Consultation Response from KC, Highways Development Management (HDM)

2024/90072 land at Bradley Villa Farm, Bradley Road, Bradley, Huddersfield, HD2 2JX

Discharge of conditions 13 (cycle parking), 14 (electric vehicle charging), 16 (waste management), 33 (air source heat pumps) and 36 (external lighting) of previous permission 2021/92086 for erection of 277 residential dwellings and associated infrastructure and access

TITLE:
BIN & CYCLE STORE DETAIL

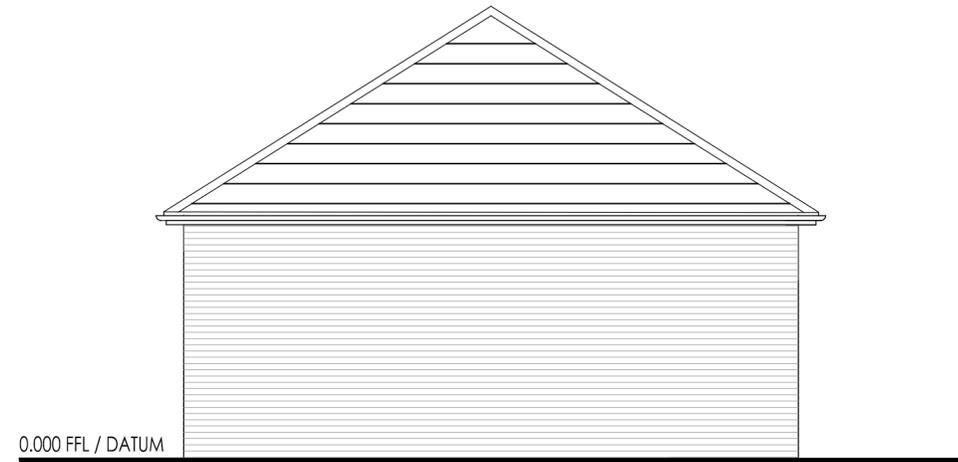
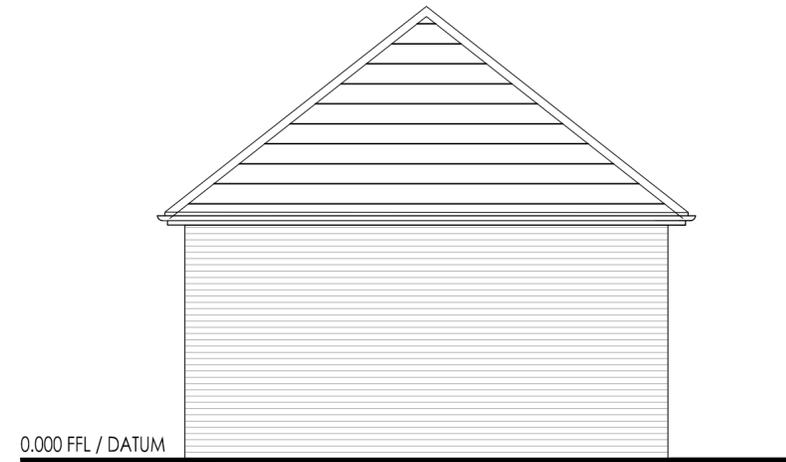
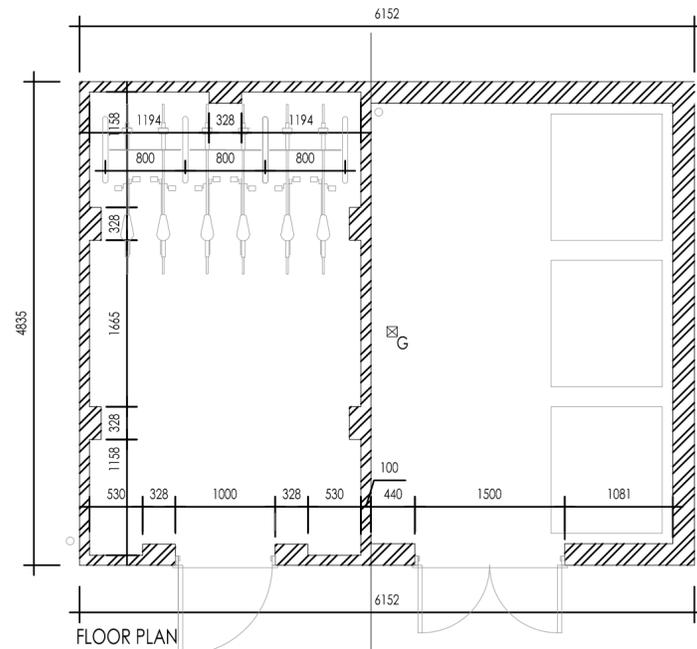
- For the apartment units, communal cycle stores are proposed, which are acceptable in principle. However, the capacity of the cycle store (including dimensions) and the quality of provision (e.g. cycle racks/stand types etc) have not been confirmed. Therefore, further detail of the communal cycle stores are required, which must be inclusive, and cater for a range of bike types (e.g. Min. 5% provision for adapted cycles for disabled users – See LTN 1/20 guidance). It is also noted that there is no path leading to the Plot 204-212 cycle store, which needs to be incorporated.
